Response to Request for Information for Eastern Creek Quarter - Lot 1 Detailed Design (SSD-8858 MOD 2)

Ethos Urban has prepared this letter on behalf of Frasers Property Australia (Frasers) in response to the Department of Planning, Industry and Environment's (the Department) additional request for information (RFI) letter dated 27 October 2021 and email correspondence dated 4 November 2021.

PROPOSED GROUND FLOOR PLAN 1 : 500

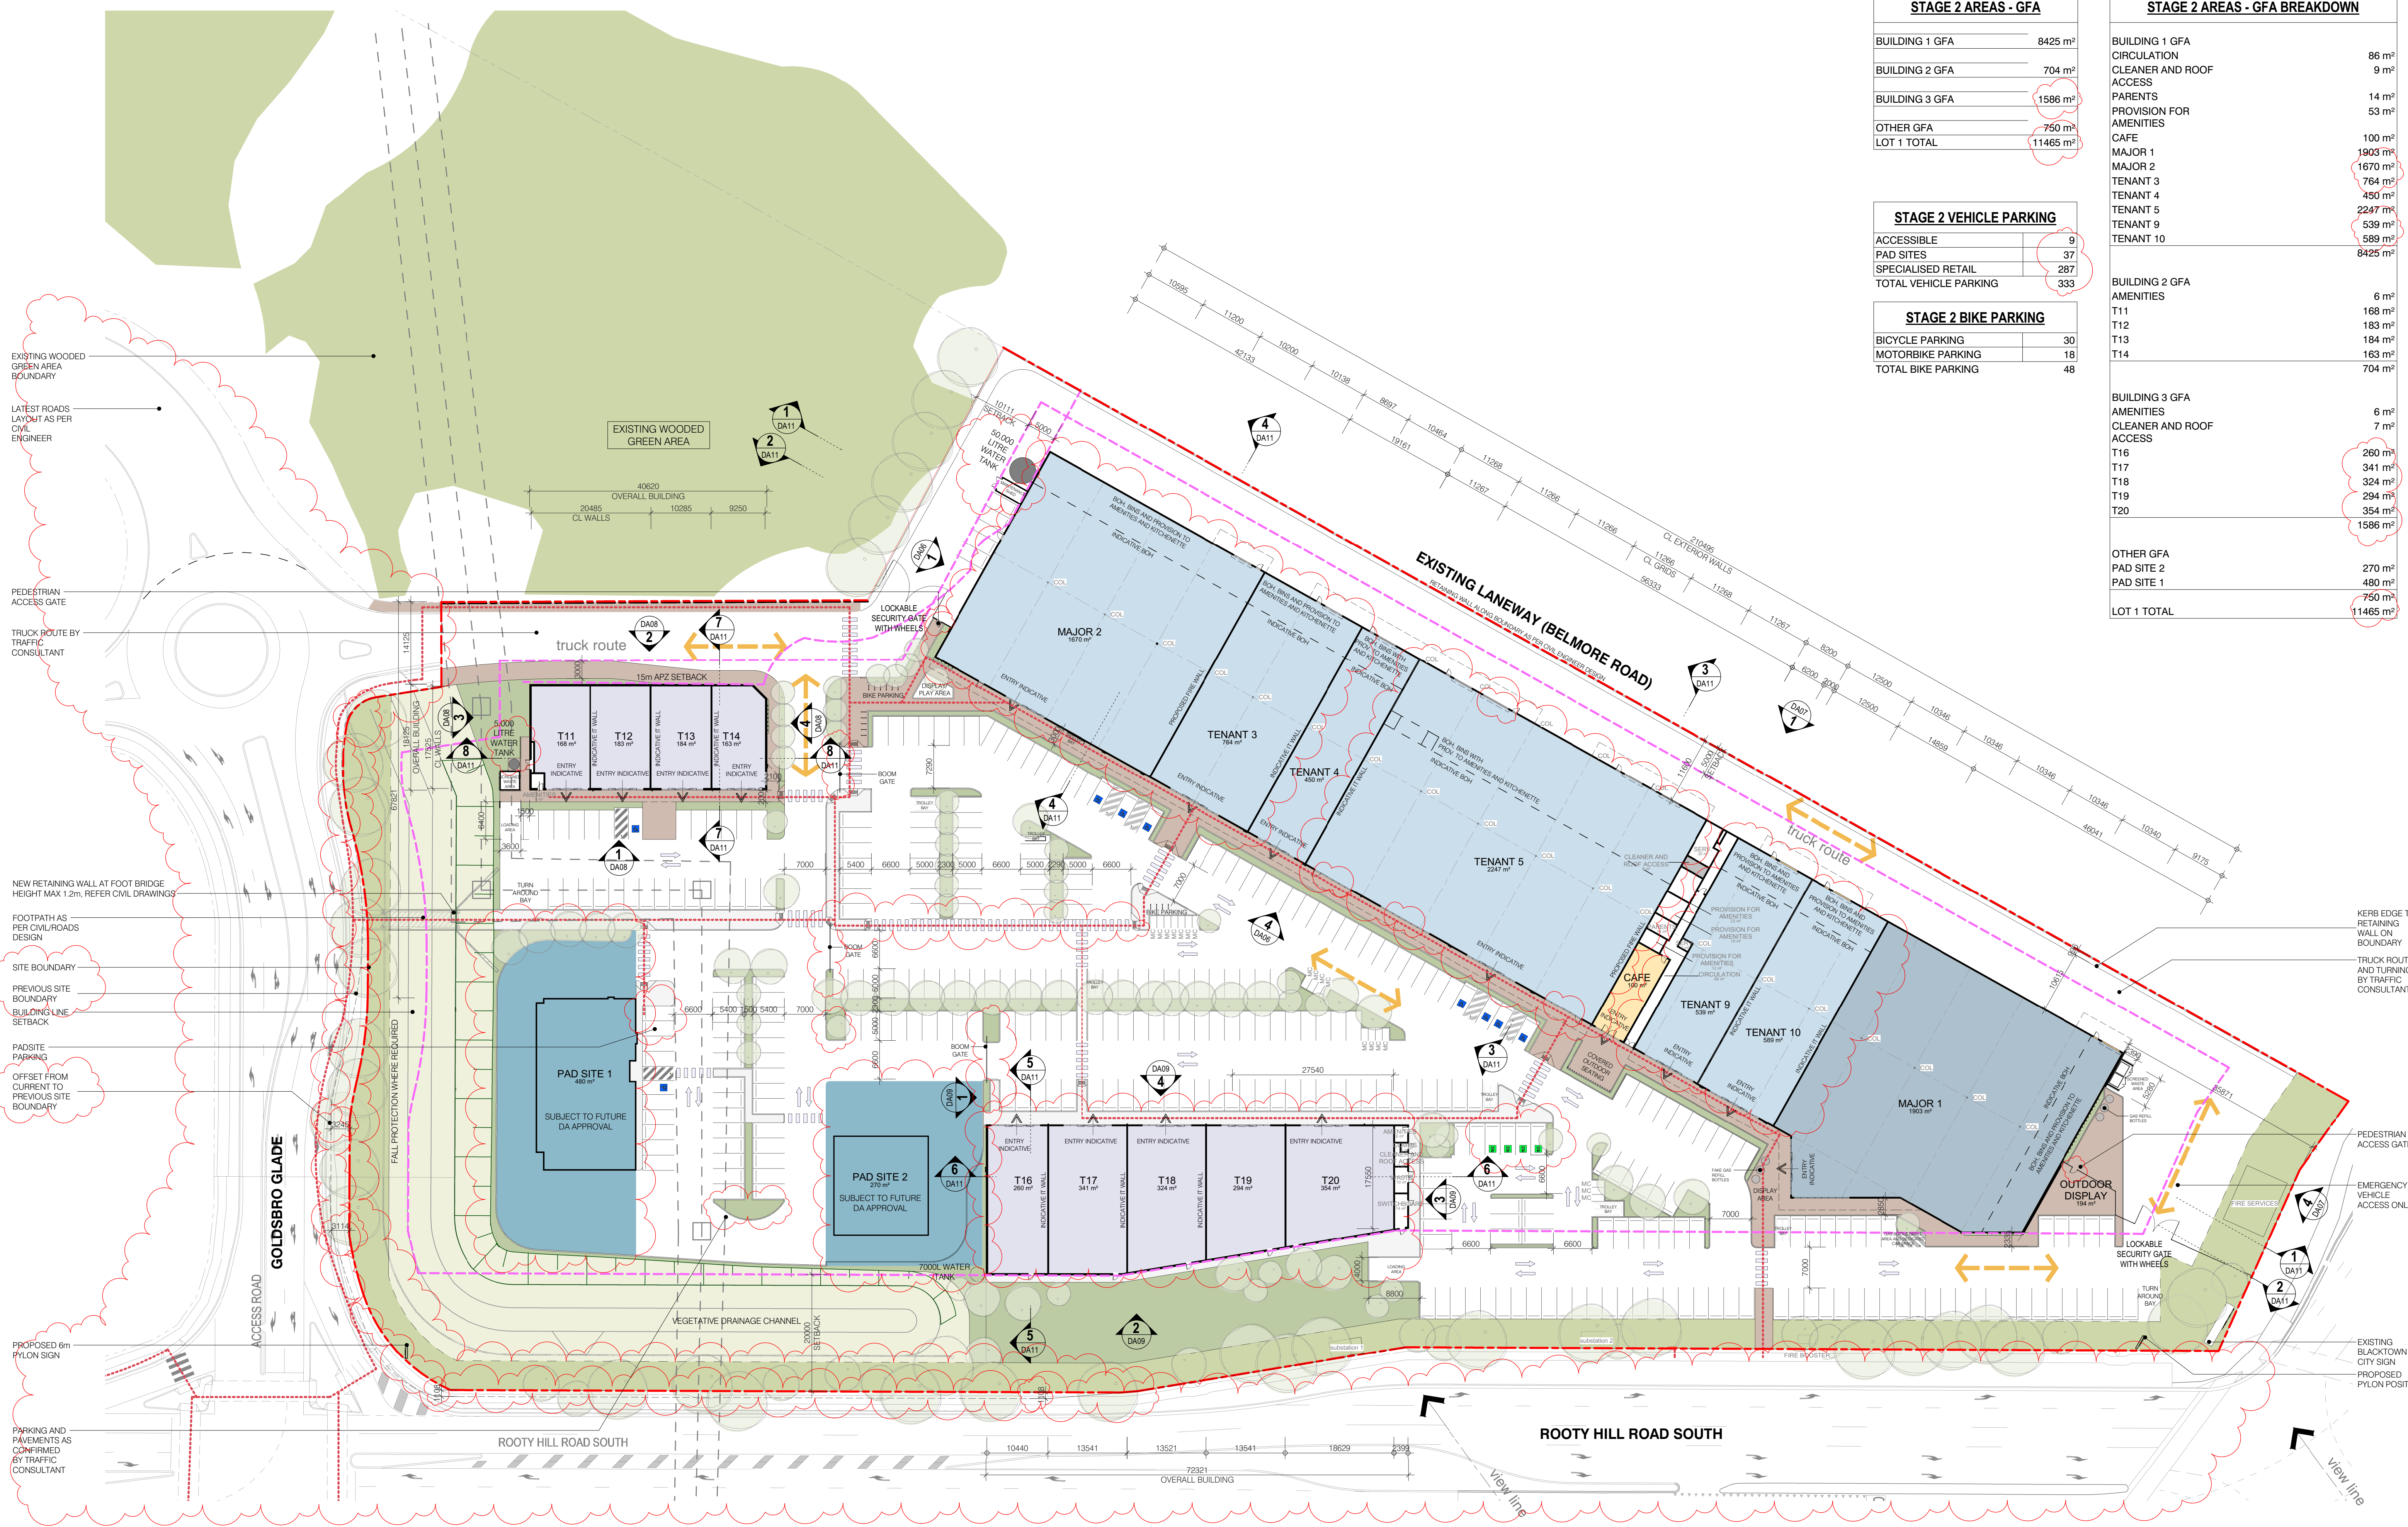
- Updated Site/Floor Plan to indicate the location of the stair roof access on the ground level of Building 2. - Confirm that this access has received BCA approval.	The roof access for each of the buildings includes a dropdown ladder. For building 2 this dropdown ladder is accessed from the amenities room shown on the Site Plan (refer to Attachment A). The construction certificate has been obtained for the design of the roof access, with these also receiving BCA approval during this process.
Updated Signage Plan (drawing no. DA21) showing for doors of Tenant 5 consistent with those in Building 1 – True Elevation	Signage – Stage 2 Plan (DA21) has been made consistent with the true elevation (DA06). Refer to Attachment A.
Updated Proposed Site Plan, Roof Plan and Signage plan, overlaying the Proposed Intersection Layout dated May 2020 prepared by Henry & Hymas (drawing No.15766_CON_C000, Rev 1) to show that the proposed site boundary is adequate to accommodate the future intersection upgrade.	Updated Architectural Plans including the requested overlay are provided at Attachment A. These plans demonstrate that the proposed site boundary adequately accommodates the future intersection upgrade.

- Omission of the roof access zones on each building and replacement with an access hatch.
- Amended the location of the water tank adjacent to building 2, to ensure consistency with the construction certificate plans.
- Amended the water tank at building 1 and shifted the door to the adjacent wall on the maintenance shed, next to the building 1 water tank, to ensure consistency with the construction certificate plans.
- Signage – Stage 2 Plan (DA21) has been made consistent with the corresponding true elevation (DA06).
- Inclusion of red clouding on signs 1M, 1O and 1P shown on Signage – Stage 2 Plan (DA21), as these dimensions have been amended to be consistent with the dimensions shown on the stamped approved Signage – Stage 2 Plan (DA20A).
- Inclusion of the intersection layout overlay on the Site Plan (DA04), Roof Plan (DA05) and the Signage – Stage 2 Plan (DA20A).

SIGNAGE ELEVATION 3A - SIGNS 1K - 1P 1 : 100

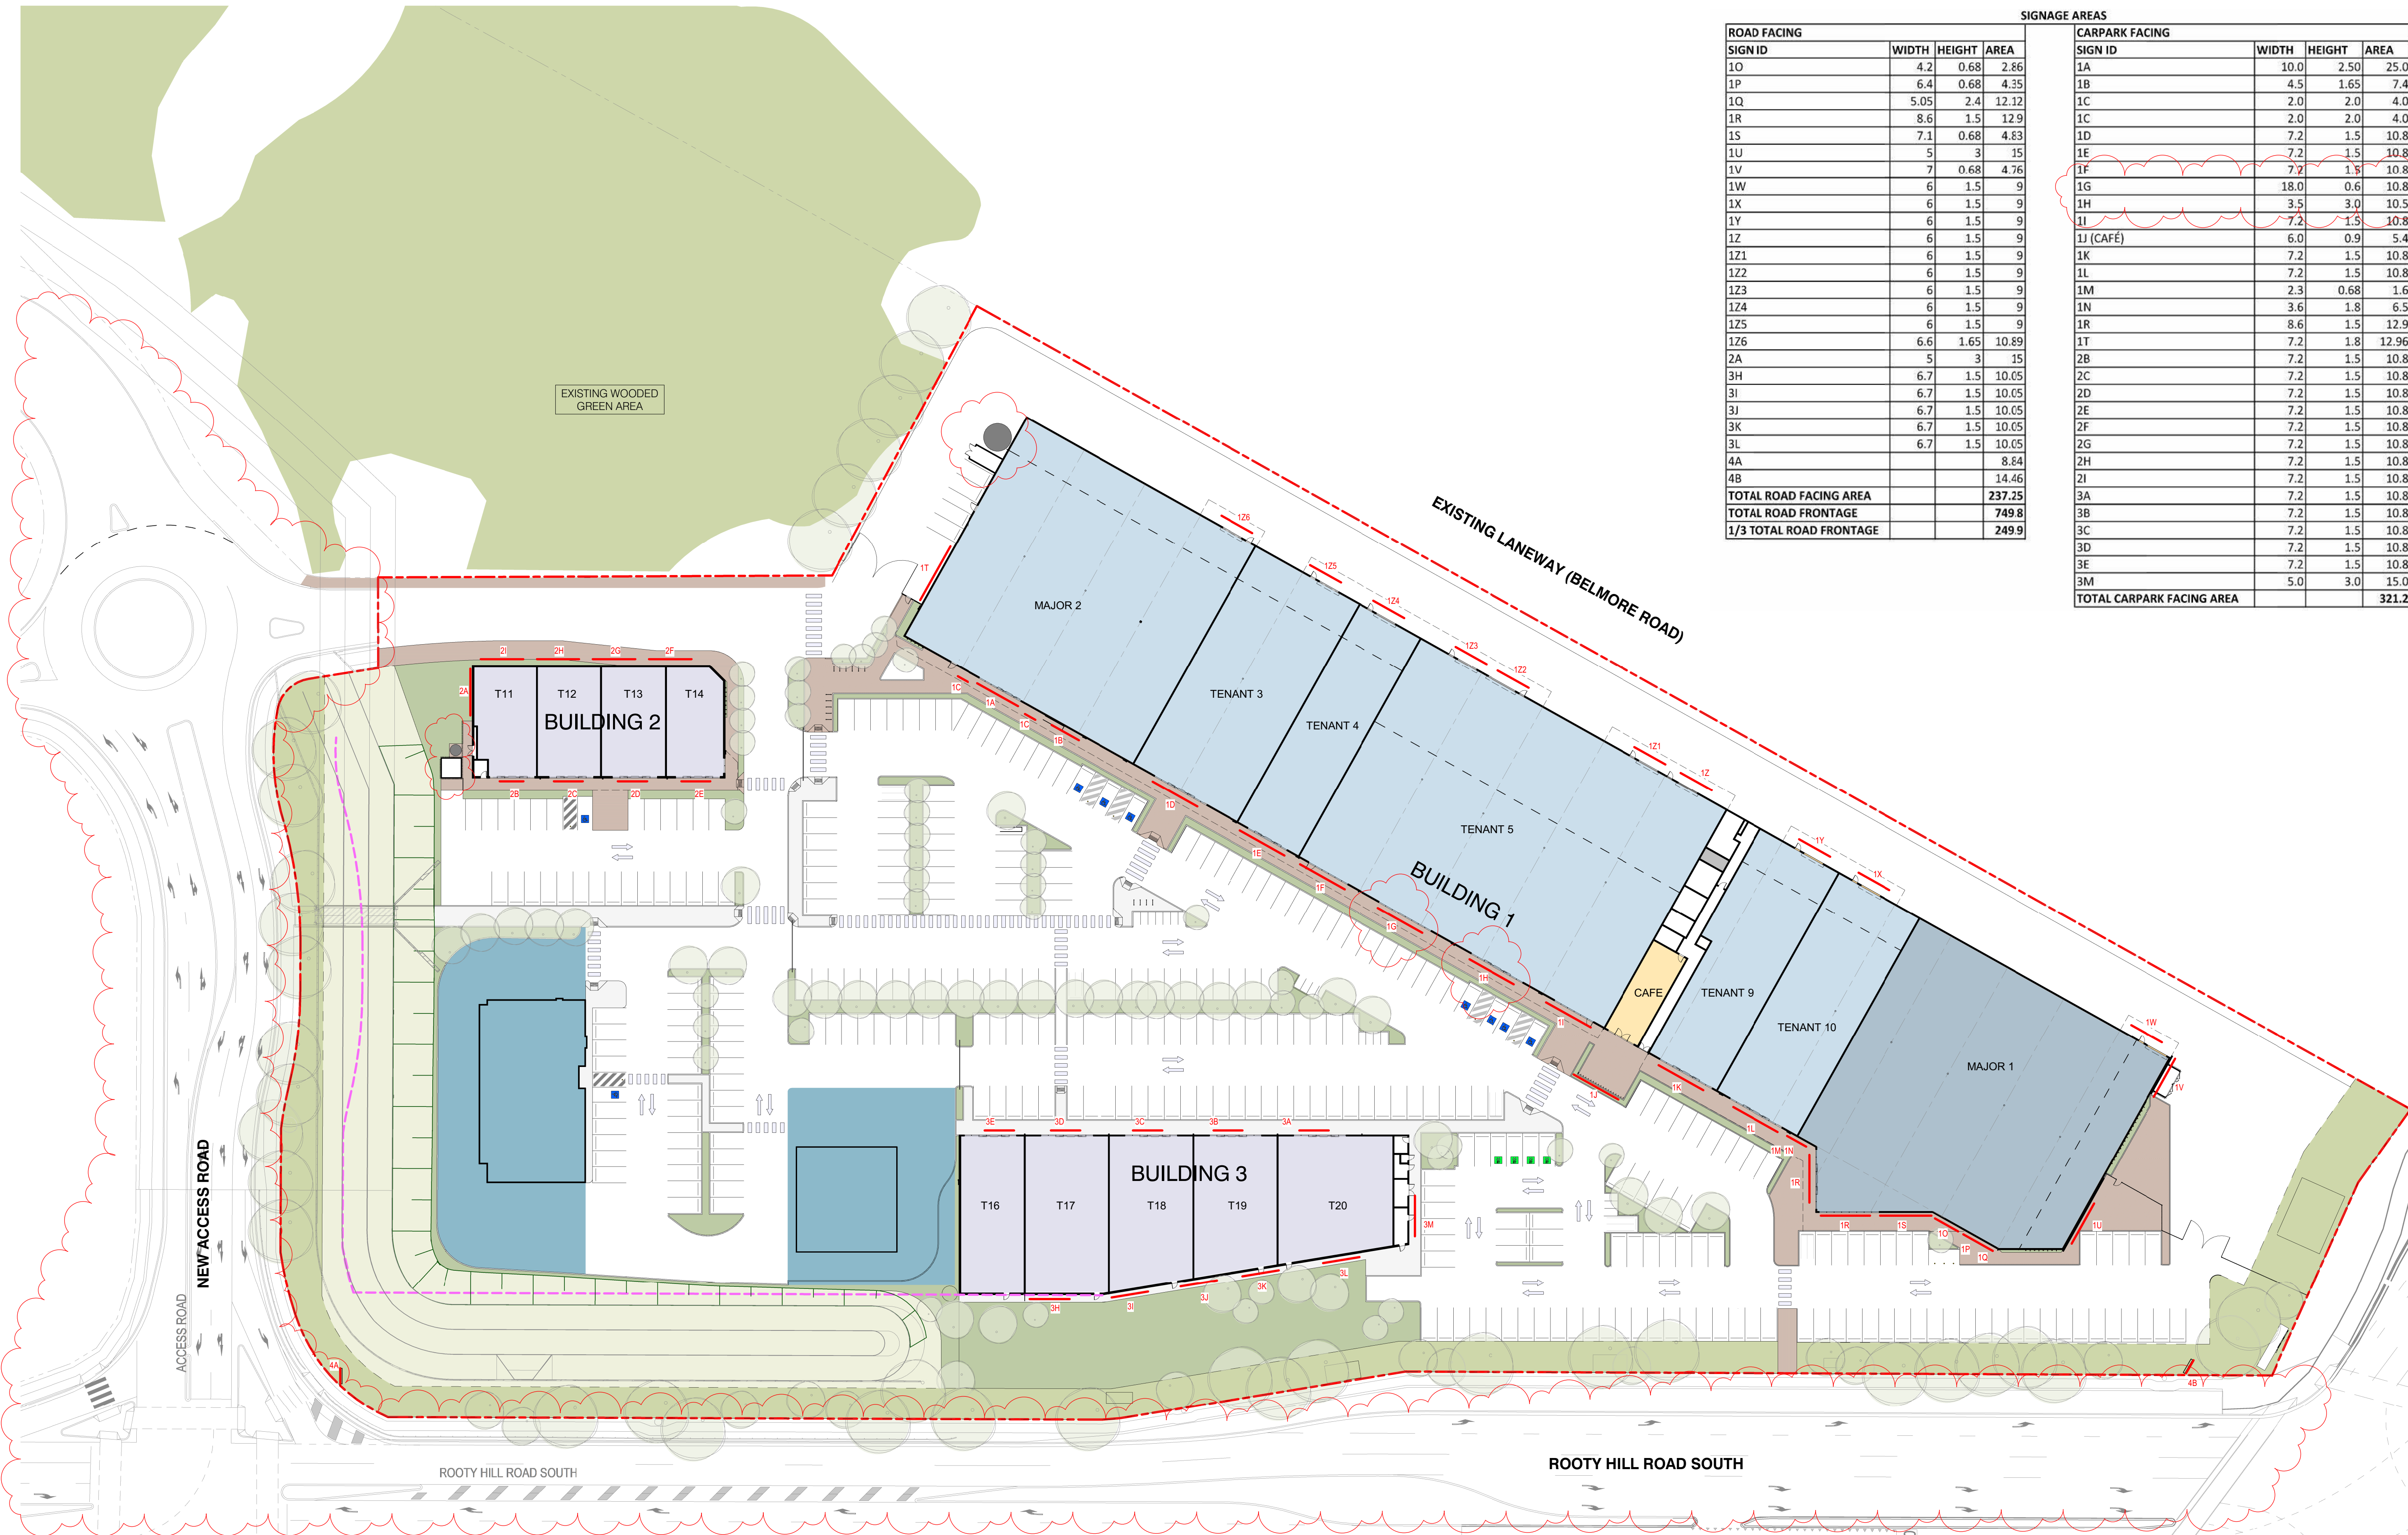
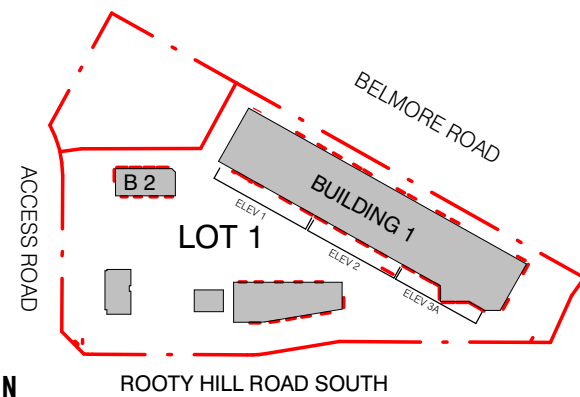
Comment	Response
Clarify the dimensions of signage zones 1M, 1O and 1P relating to Major Tenant 1.	The dimensions of signage zones 1M, 1O and 1P are as follows: Sign 1M: 2.3m x 0.68m (reduction in signage area by 2.486m²); Sign 1O: 4.2m x 0.68m (reduction in signage area by 6.144m²); and Sign 1P: 6.4m x 0.68m (reduction in signage area by 4.648m²). It is noted that these dimensions are already reflected in the schedule included in the stamped approved Signage – Stage 2 Plan (DA20A). However, Signage – Stage 2 Plan (DA21) has been amended to include these same dimensions (refer to Attachment A).
